Please upload the email below from the applicant onto Ocella for BE/27/20/PL.

Please could you confirm whether or not the stock pile is to be covered with an impermeable membrane in order to prevent erosion/weed growth or consists of material less permeable than topsoil.

TOP SOIL RELOCATION  
 SITE PLAN  
 1744-TS-P02-E

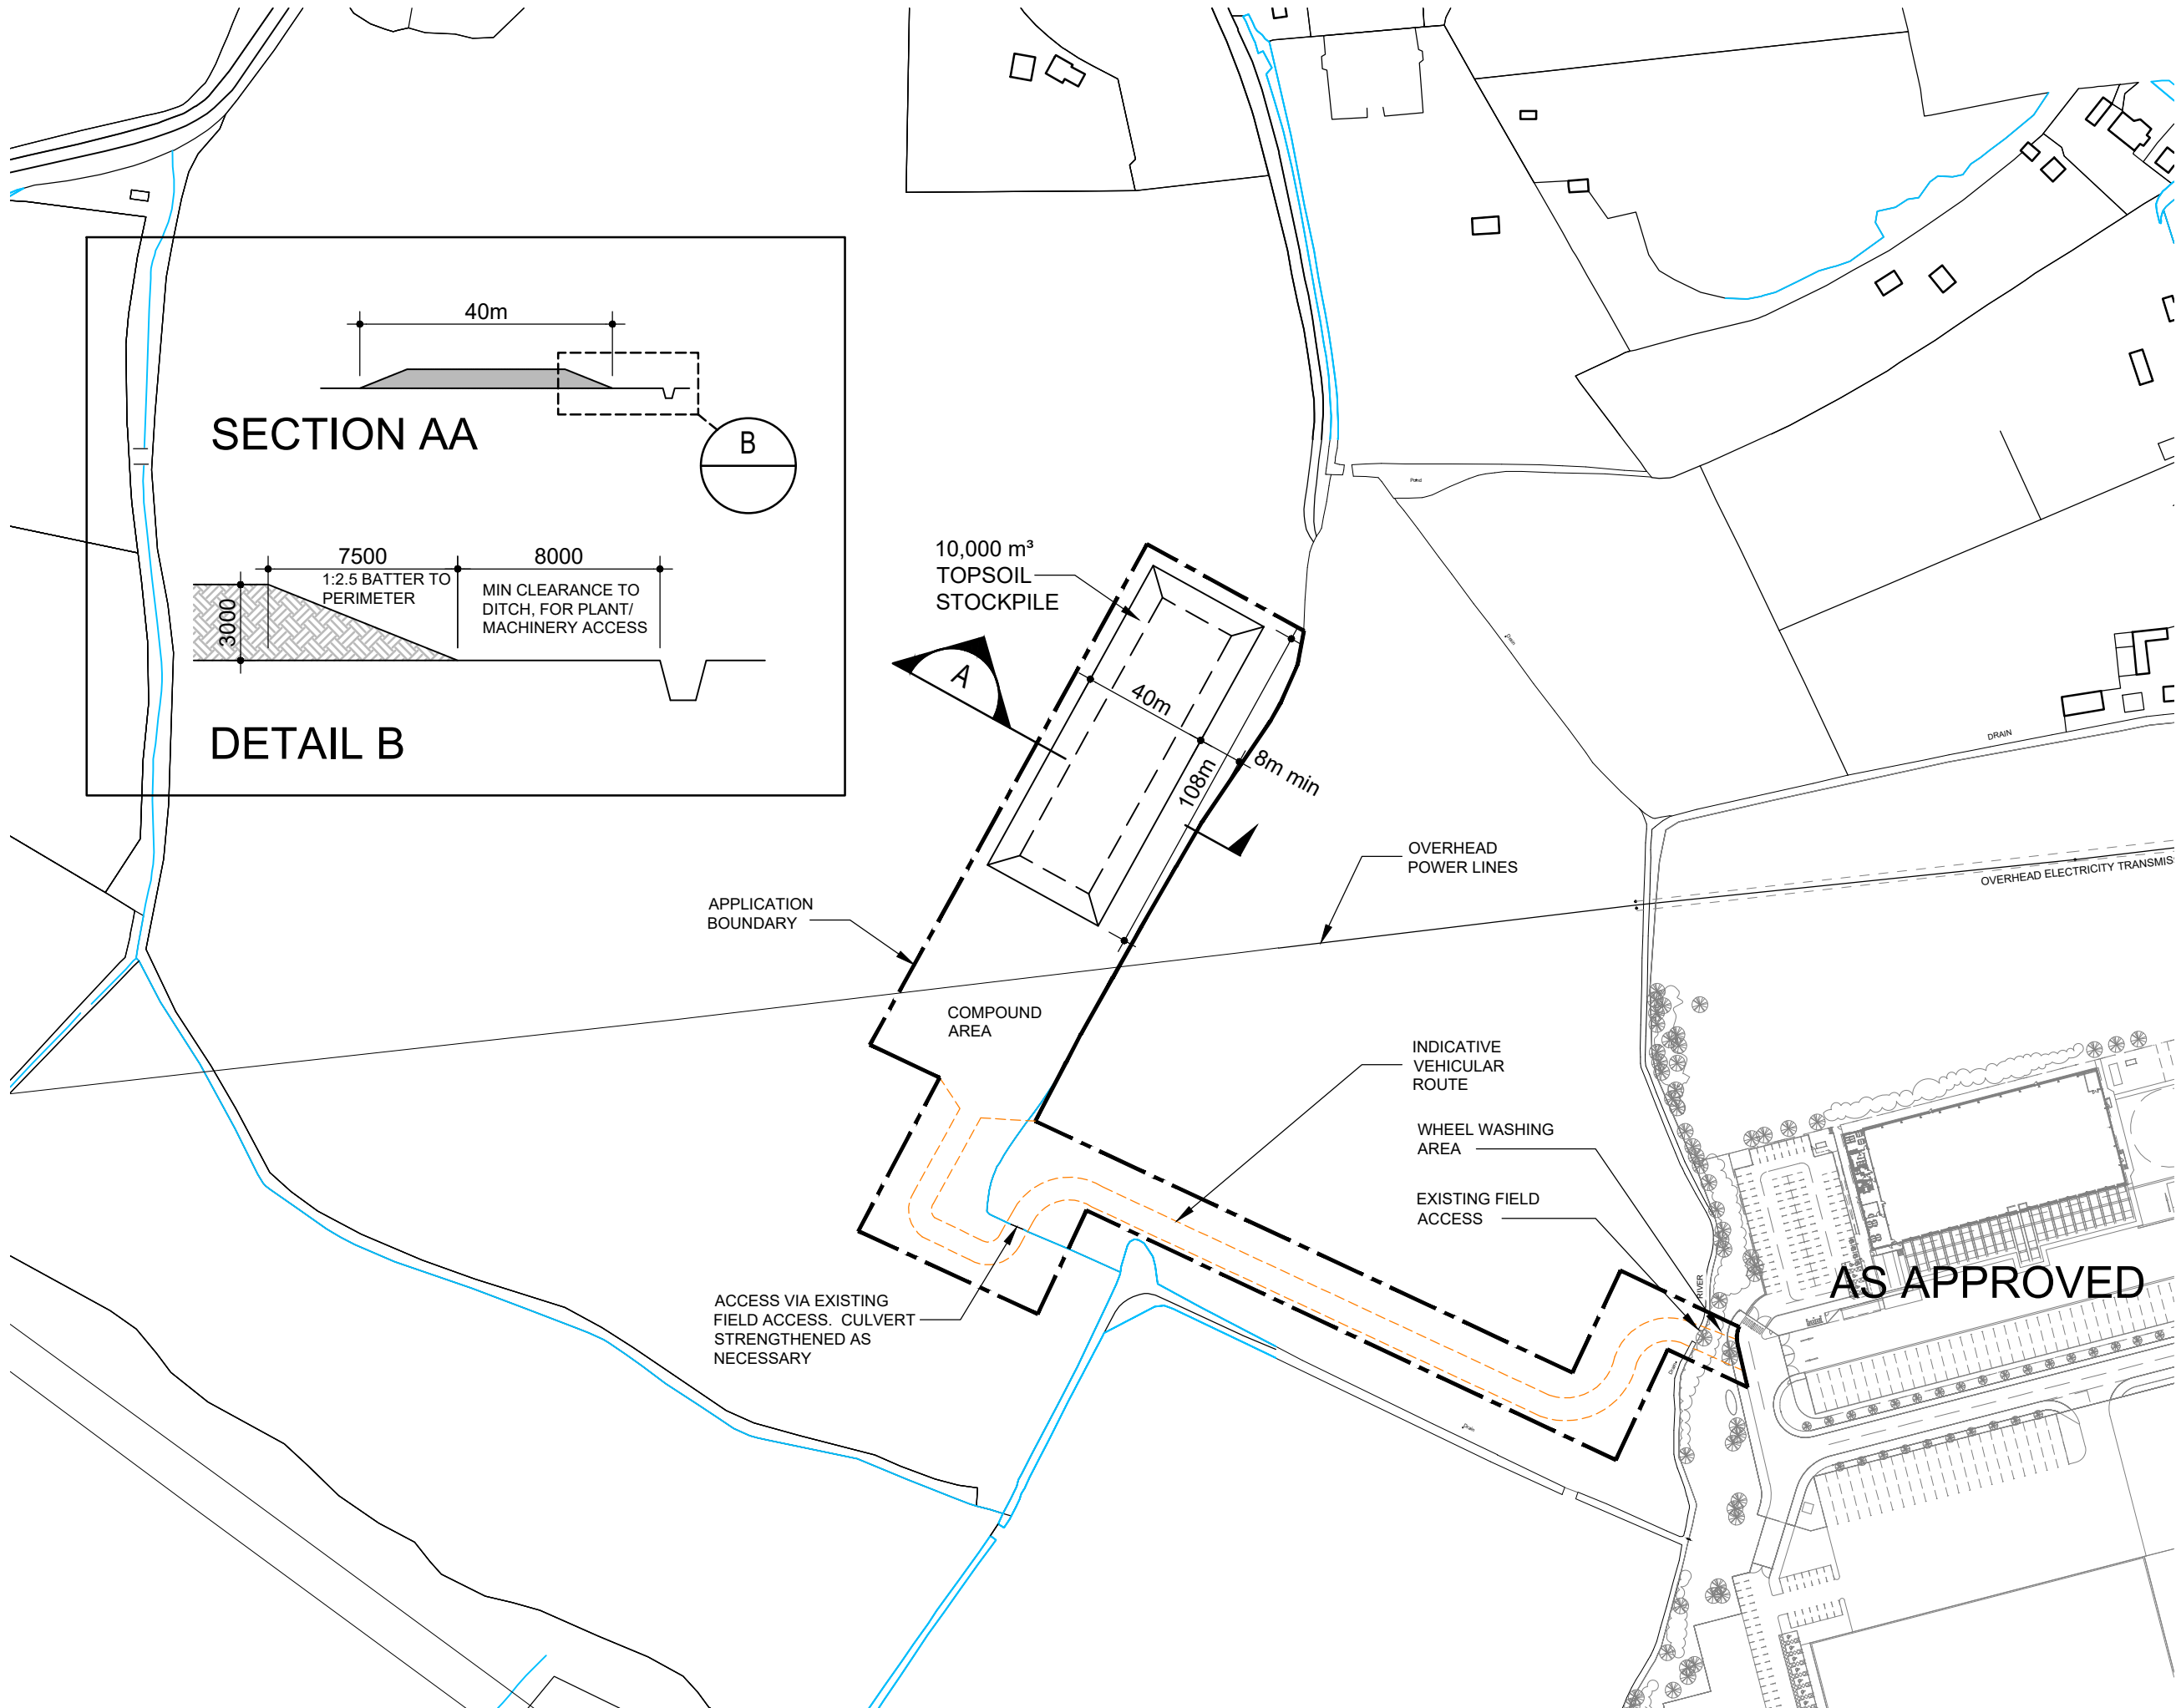
If the stock pile is to be covered then drainage measures would be required to ensure that the surface water run-off does not increase flood risk elsewhere.

Thank you for your email. I can confirm that as per the previous application, there will not be any covering of the stockpile and therefore no need for drainage measures.
